Your Ref: OWPC20561
Our Ref: BR/254/18/A 26-09-2018
Please ask for:
Amber Willard

Town & Country Planning (Control of Advertisement) (England) Regulations 2007 (as amended)

4 No. non-illuminated advertisements at various locations.
Hothampton Gardens & Surrounding areas Bognor Regis

DRAWING TITLE
SITE LOCATION AND BLOCK
PLANS

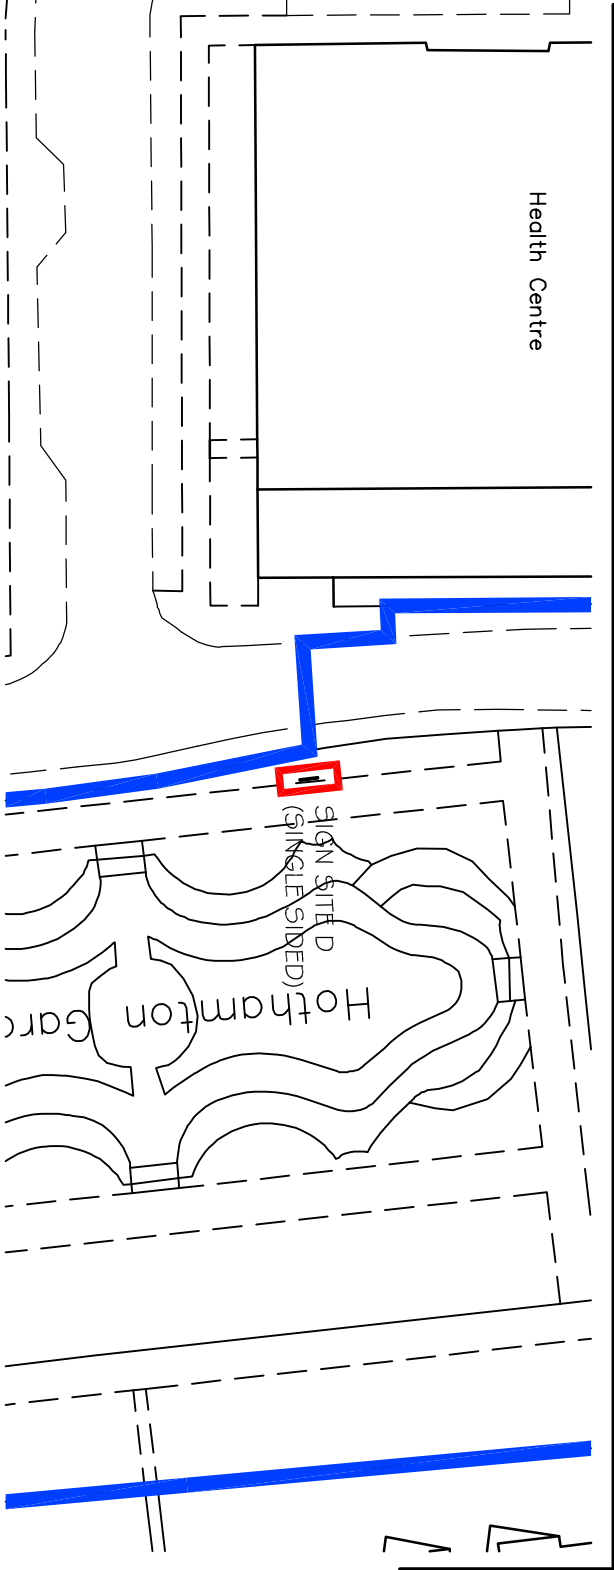
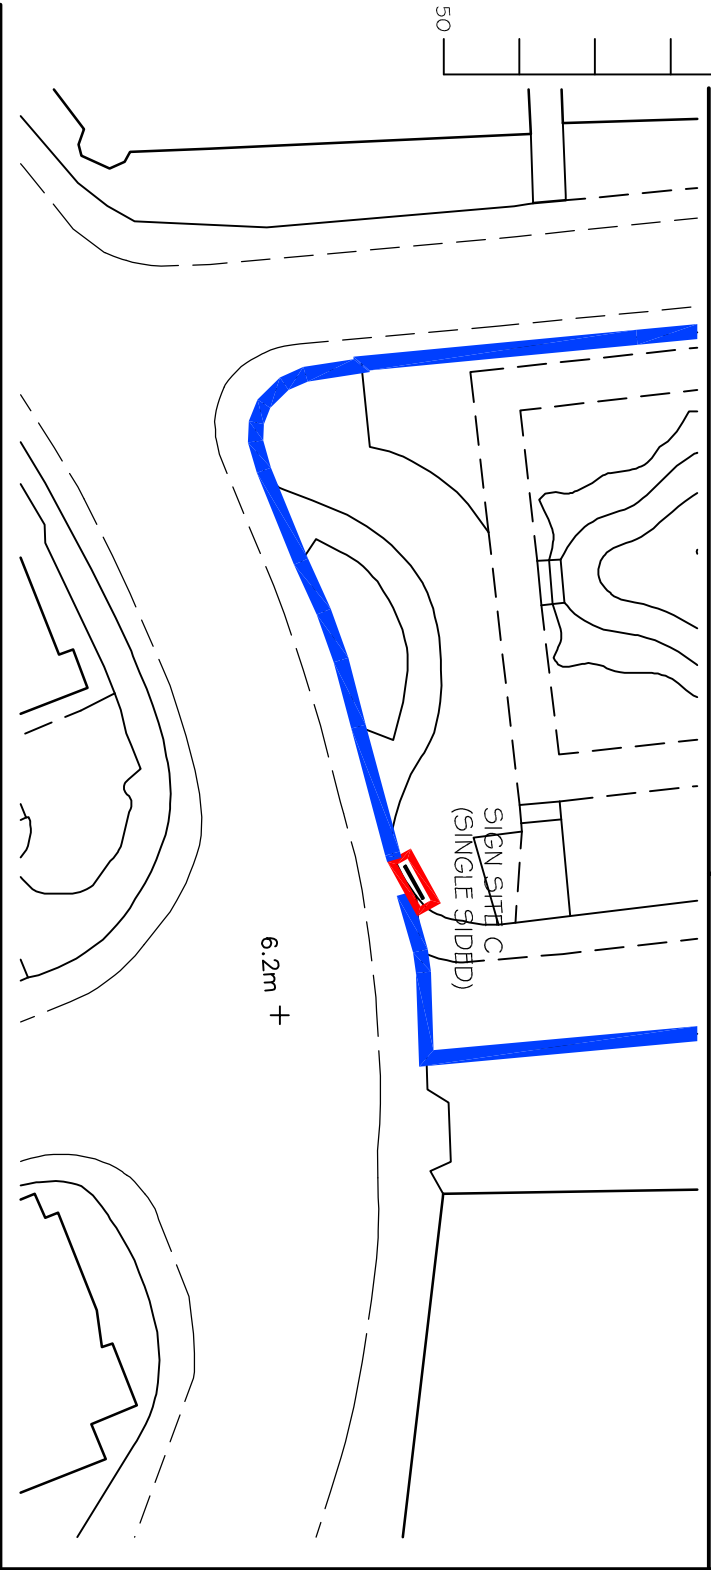
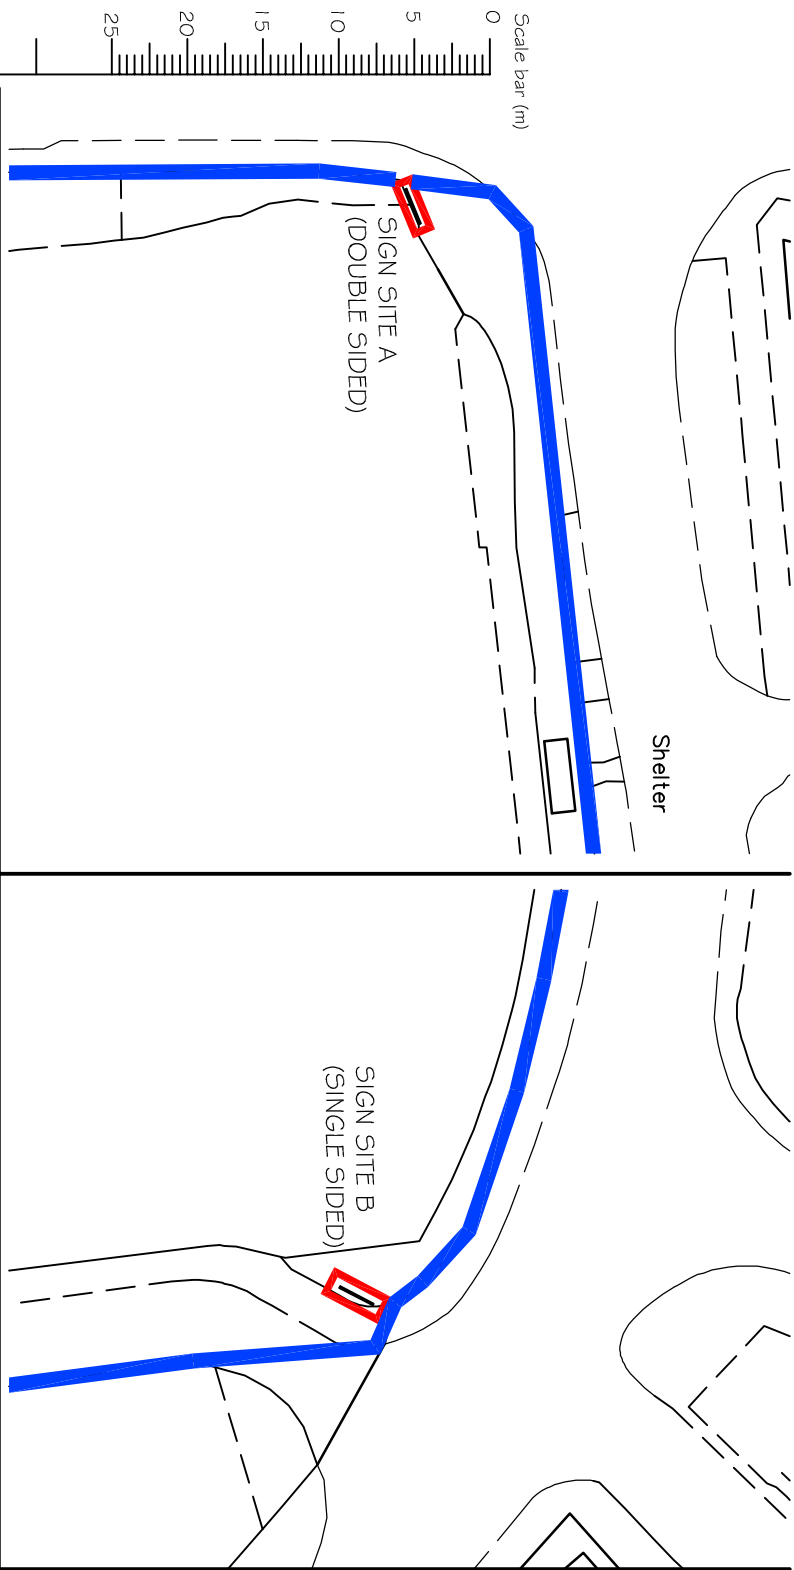
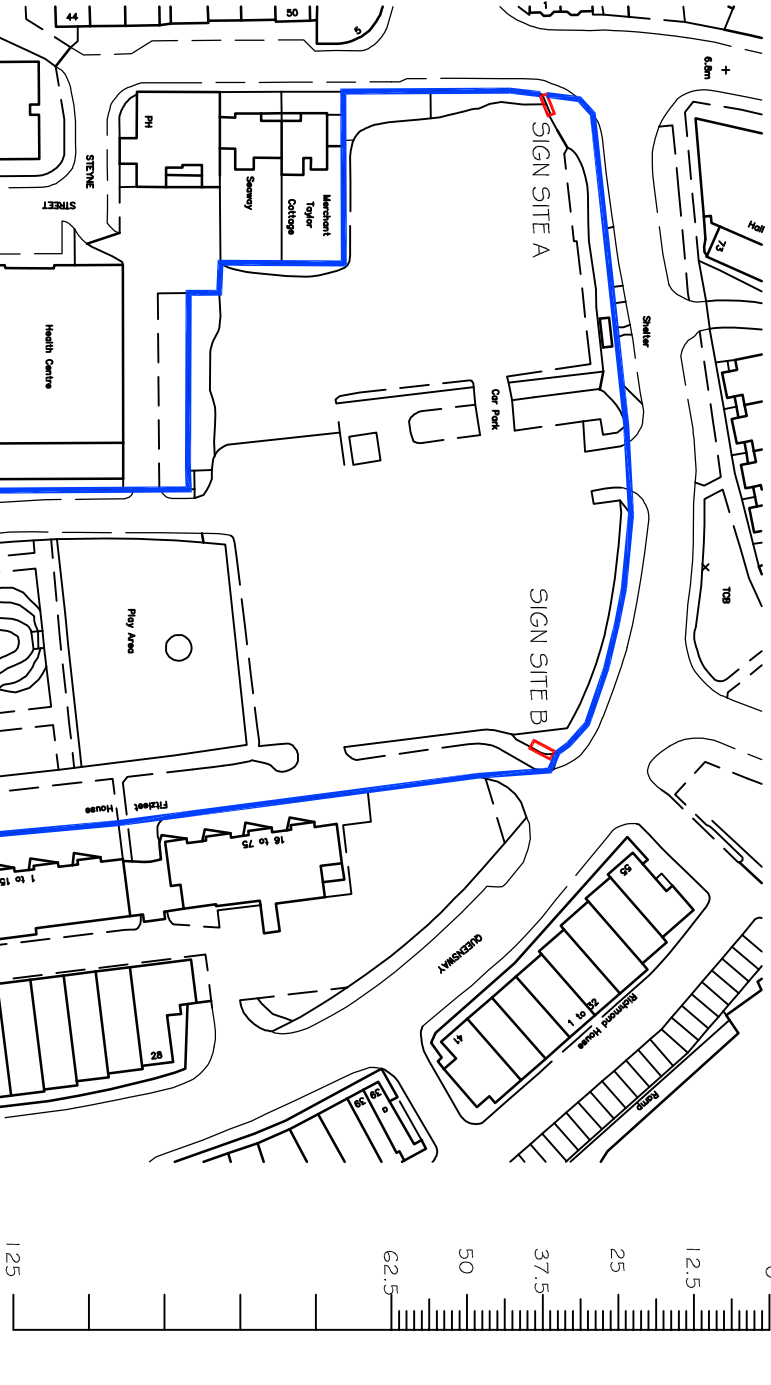
One of the proposed boards is on the boarder of the Steyne Conservation Area facing directly into the Waterloo Square, this will greatly affect the look and feel of this historic area.

Three of the boards are extremely close to the highway and the information on these boards will provide motorists with an unnecessary distraction around junctions highly populated pedestrians.

I also have concerns that with 2 of the boards being so close to the Gardens themselves and no thought has been taken into researching the effect on Birds, or potential Bats or Owls in the area.
